WEST SUSSEX COUNTY COUNCIL CONSULTATION

TO:	Arun District Council FAO: Mrs A Gardner
FROM:	Highways, WSCC
DATE:	24/05/2018
LOCATION:	78, Langbury Lane, Ferring, Worthing, West Sussex, BN12 6QE
SUBJECT:	FG/65/18/PL Single storey rear side ground floor extension, first floor dormer, alterations to east & west doors & change of glass to obscure in all bedrooms.
DATE OF SITE VISIT:	
RECOMMENDATION:	☒ Advice ☐ Objection ☐ Modification ☐ No Objection ☐ More Information ☐ Refusal
S106 CONTRIBUTION TOTAL:	£N/A

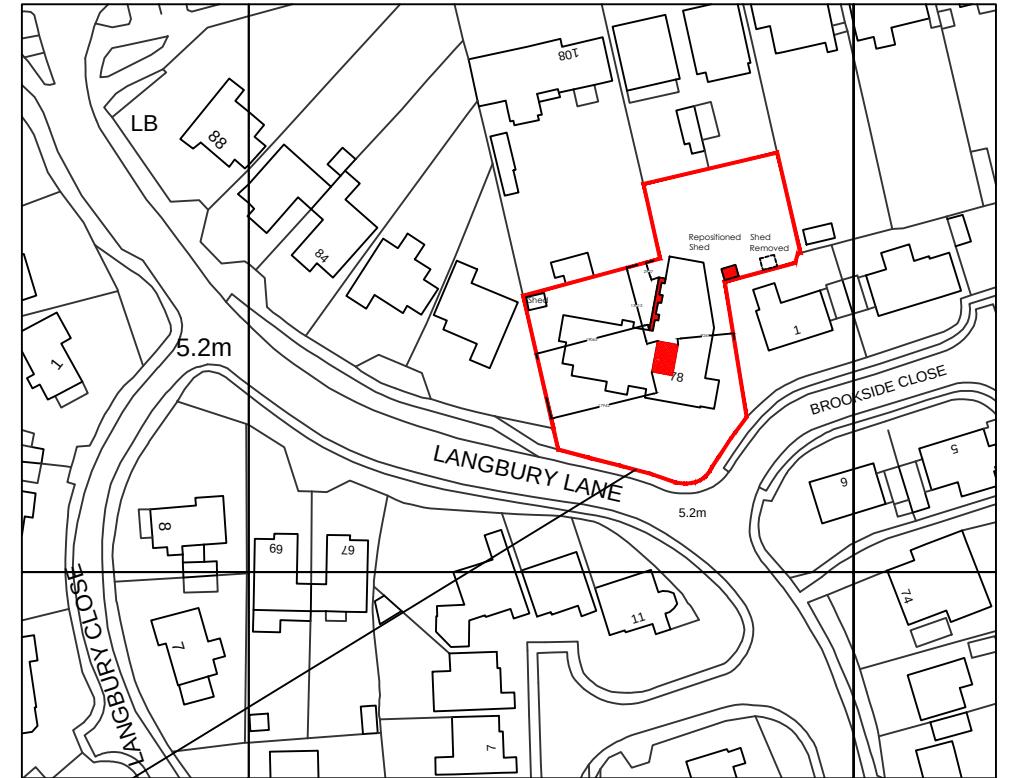
A license to construct the vehicular cross over would need to be obtained from the Arun Area Engineer. It should be noted that a license at this location is unlikely to be granted; this area is subject to a policy that a license would not be granted for a second, new, crossover to any property, due to the existing parking pressures and the loss of on-street parking provision for neighbouring residents. It is recommended that the LPA consider the amenity impact of the proposed development should permission be granted.

The local Area Engineer has now visited the site and confirmed that this additional vehicular crossover in this location would **not** be approved.

It is advised that the applicant consults the Area Office in order to discuss the access details and proposals further, please call 01243 642105.

No part of the development shall be first occupied until such time as the vehicular access serving the development has been constructed in accordance with the approved drawing.

No part of the development shall be first occupied until the car parking has been constructed in accordance with the approved site plan. These spaces shall thereafter be retained at all times for their designated purpose.
